Consultation on planning application, 3/2024/0853, Land off Longridge Road Hurst Green BB7 9QP

Response from the Parish Council

Proposed roof over livestock Gathering area

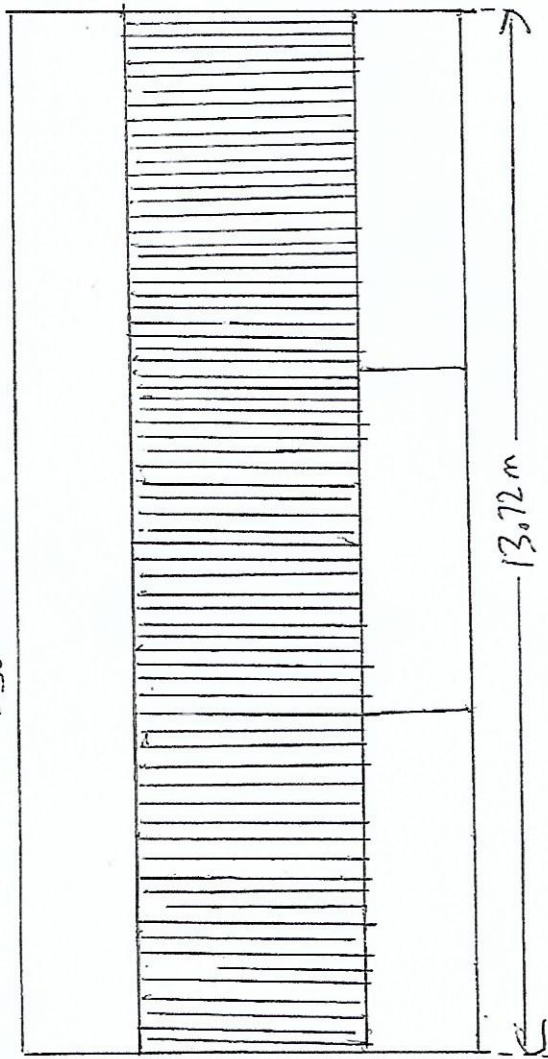
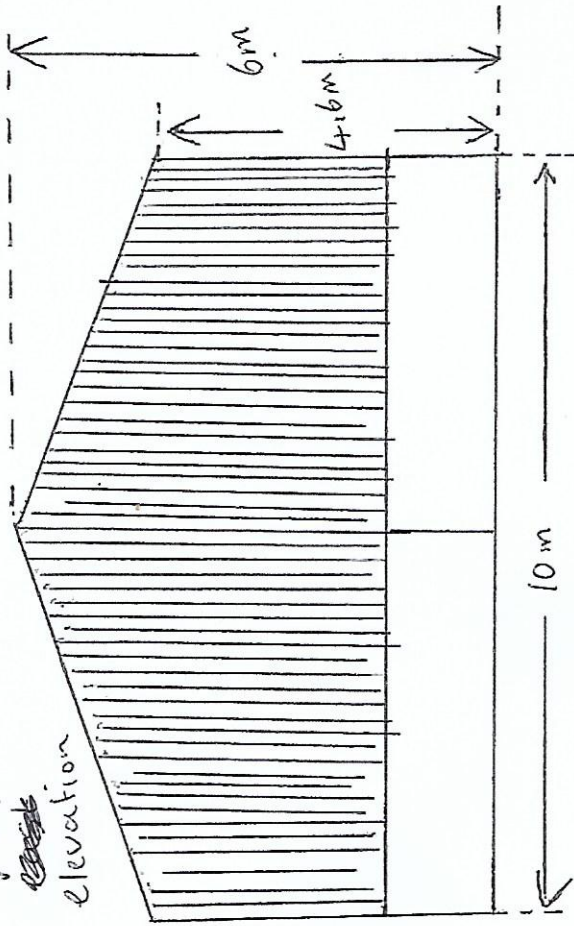
1. The Parish Council originally questioned whether there was an 'existing' stock gathering pound, as this had only been erected in October 2024, and may never have been used for stock gathering, and therefore could not be described as 'existing' in any meaningful sense.
2. The amended proposals of 13th January 2025 are for a site where there is not even an existing stock pen, let alone a convincing case for a need for one, and yet still refer to an 'existing' pen and run off from this.
3. Both sites are in open countryside in the AONB, and would have a detrimental impact on the visual environment.
4. The location plan continues to infer that the whole of the lane is in the ownership of the applicant, but we understand that this is in doubt.
